Rezoning Transportation Analysis

Petition Number: 2021-163

Date	Description
08-26-21	First Review (LH)
09-23-21	Second Review (BKB)
10-28-21	Third Review (BKB)

Uptown CycleLink 6th Street Cycle track and other streetscape enhancements along 7th Street. Site plan revisions are needed to meet outstanding items including, but not limited to:

2 - 6TH ST. STREET SECTION E  
SECTION

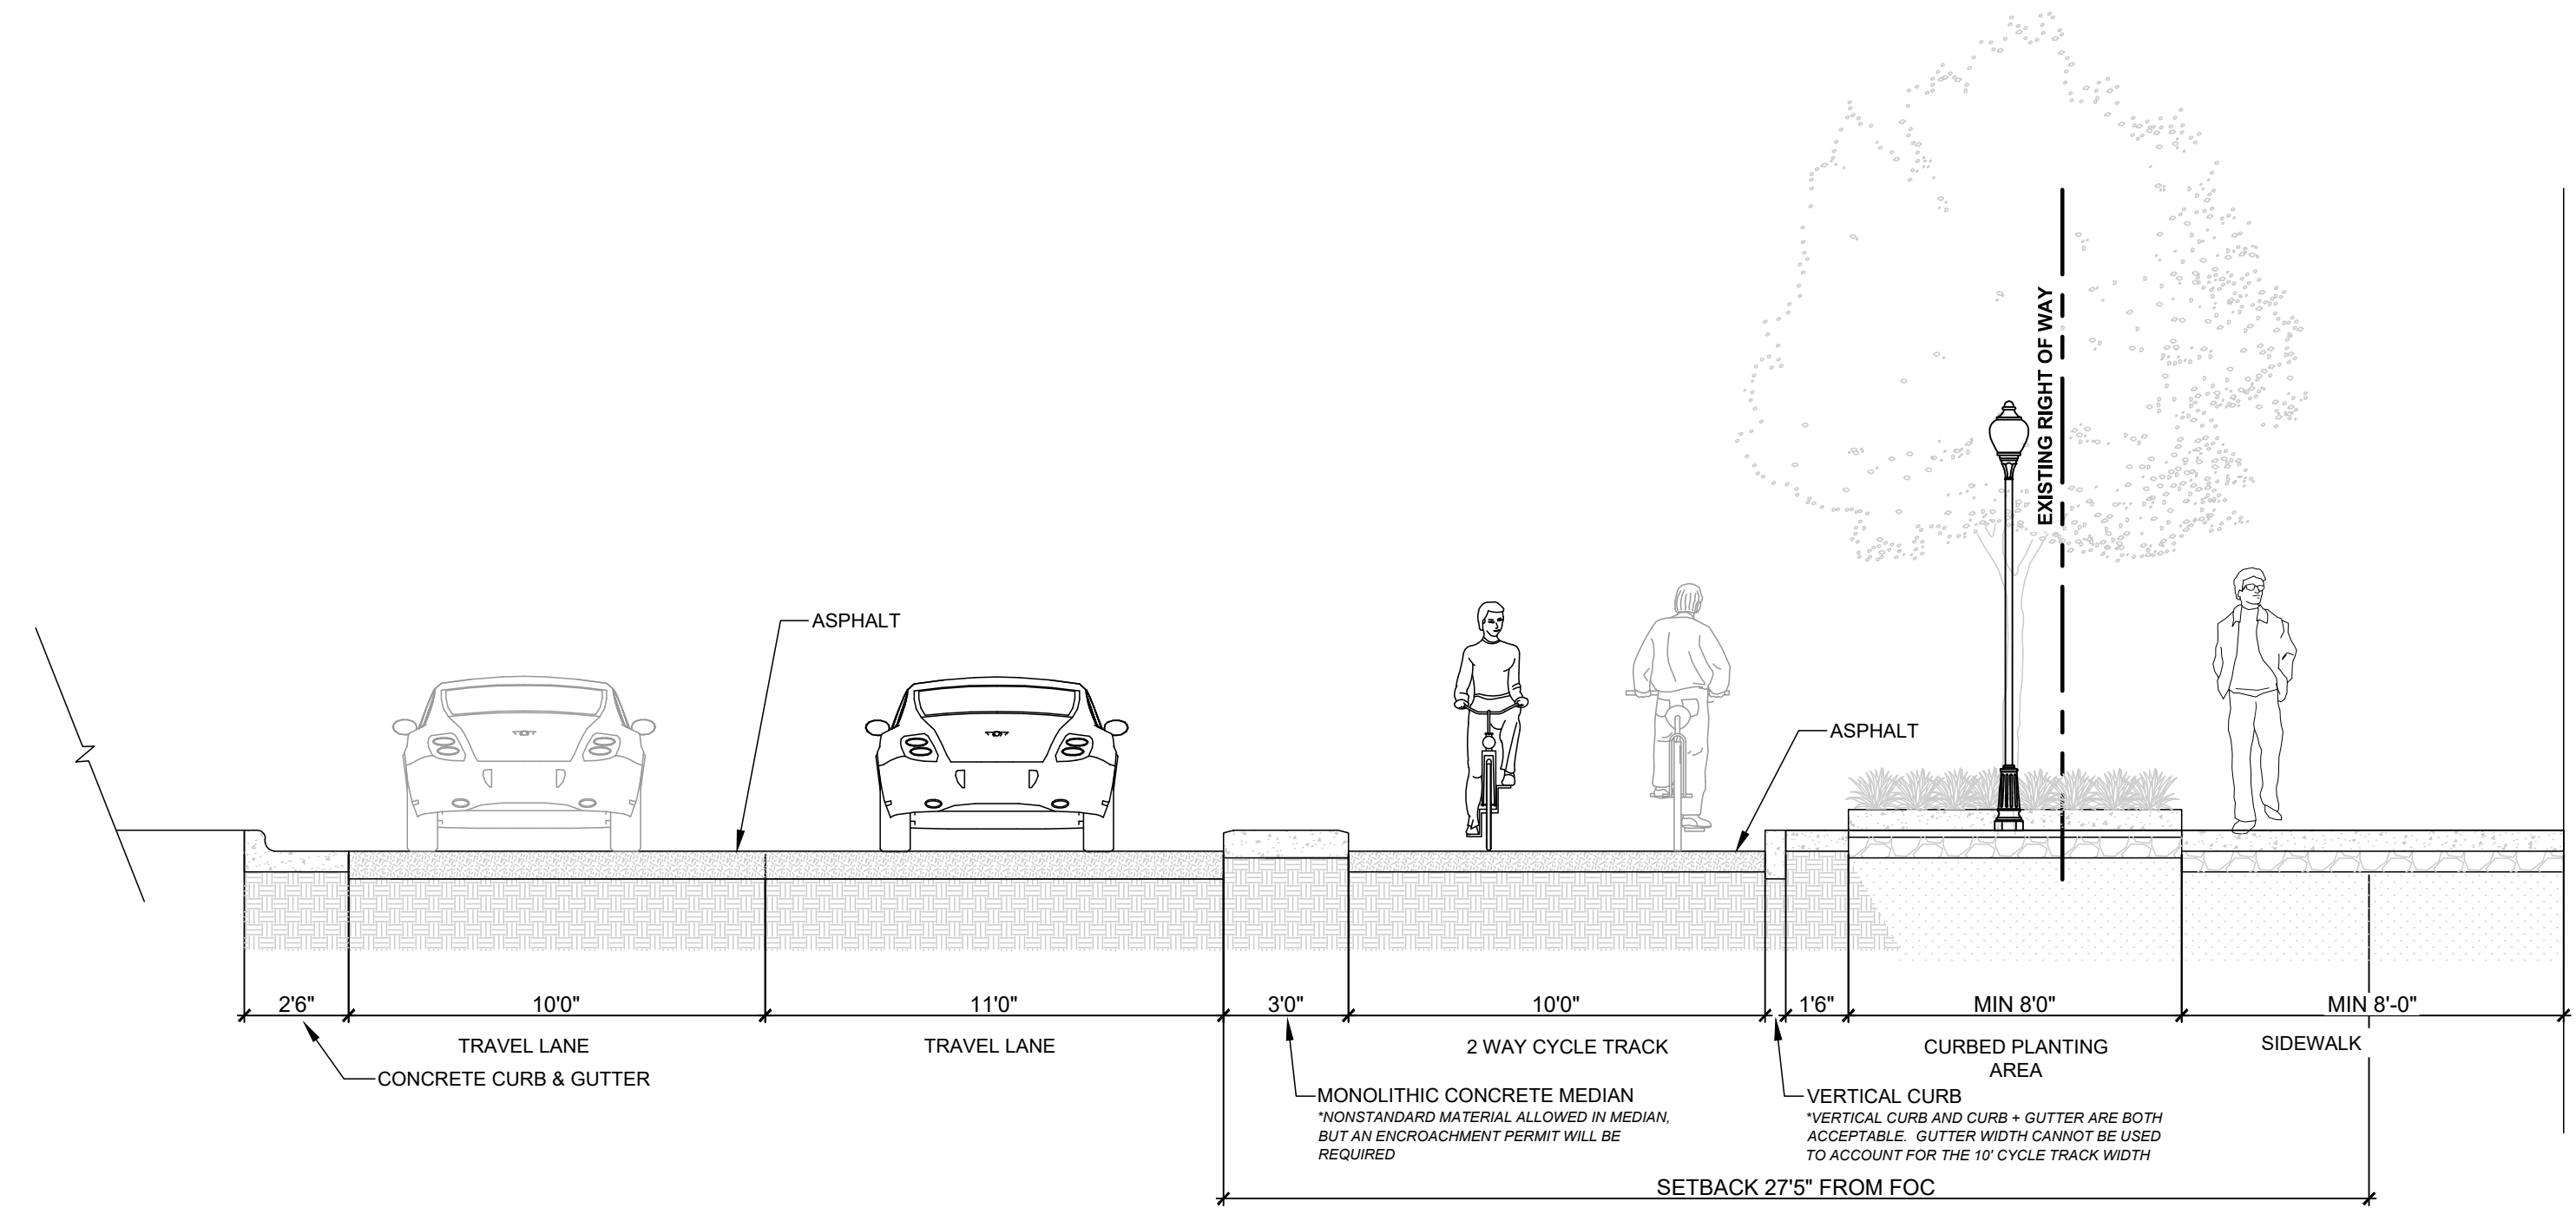
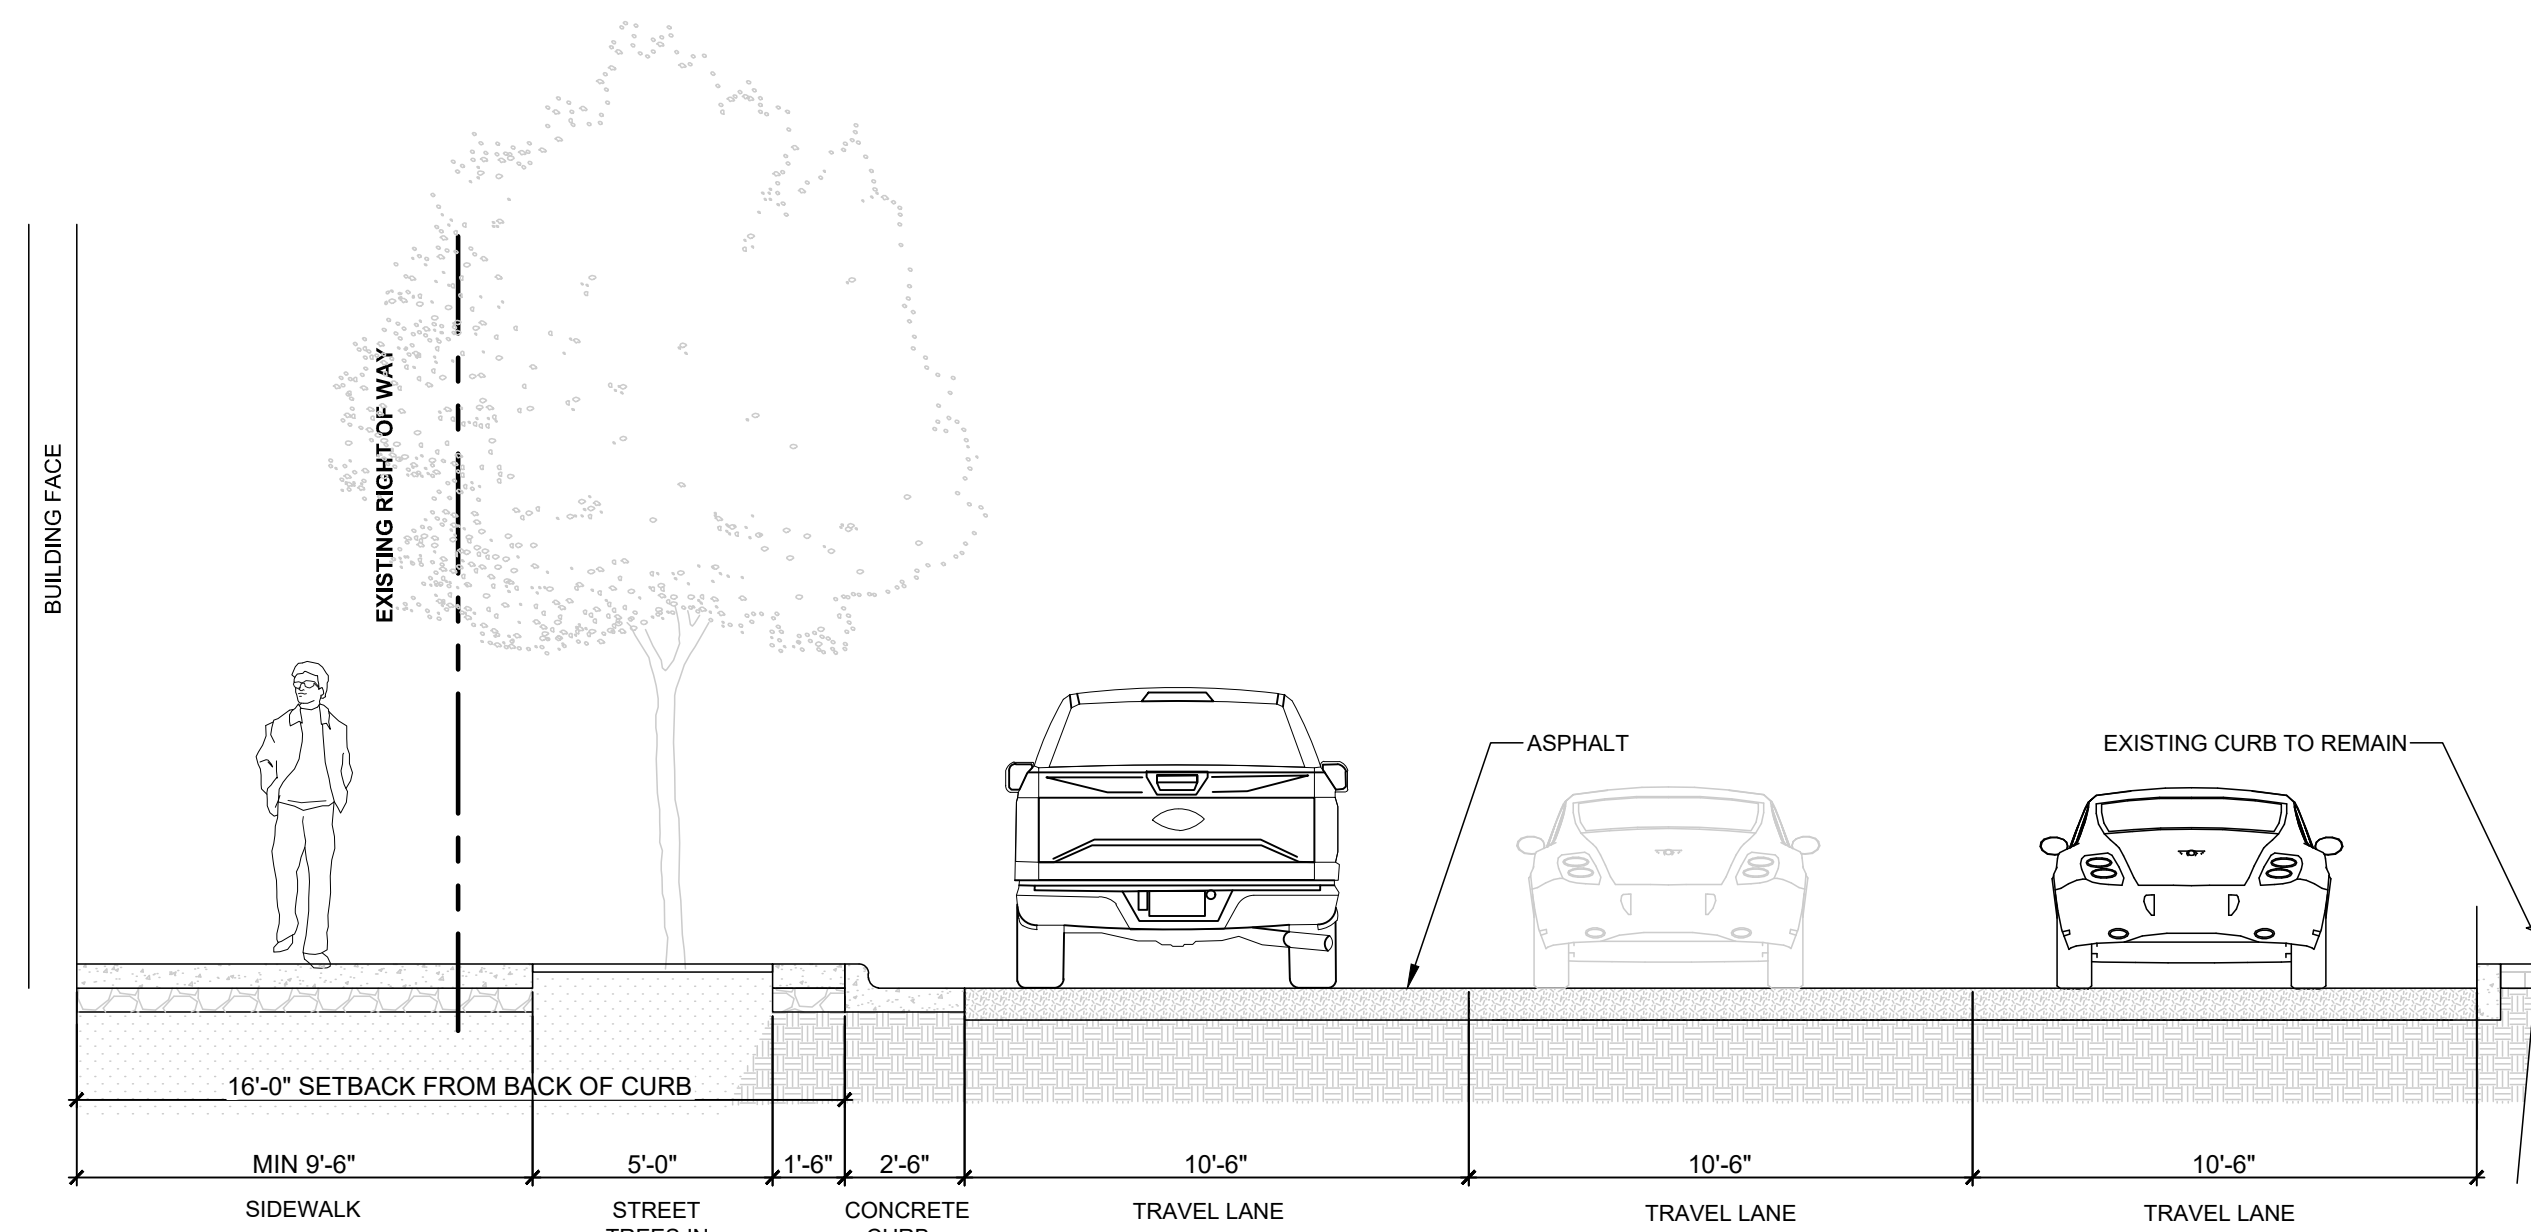
4. **6th Street Cross-Section:**
 - ~~a. **New Cross-Section:** Include a second cross-section that shows a consistent 10' cycle track width and 11' travel lanes.~~
 - ~~b. **Right of Way:** Show right of way line on cross-section and ensure building face is outside of right of way.~~
 - ~~c. **Pedestrian Pathway:** Update site plan and conditional notes to show minimum 12-foot sidewalk width. **Updated per Site Plan Dated 09-13-2021: 8-foot minimum sidewalk consistent with all other streetscape improvements in area. Verify that 8-foot sidewalk is achieved as it appears to be less than that in an area below the dimension on the site plan:**~~

d. **Cycle Track:** Update site plan and conditional notes to show the correct and varied dimensions, as shown below. Add a conditional note that vertical curb and curb and gutter are both acceptable adjacent to the cycle track, but the gutter width cannot be used to account for the 10' cycle track width. Add a conditional note that nonstandard material is allowed in median between cycle track and vehicle travel lanes, but an encroachment permit will be required. Additionally, provide a conditional note that specifies the commitment of constructing the cycle track on 6th Street.

e. **Dimensions:** Adjust dimensions as shown below:
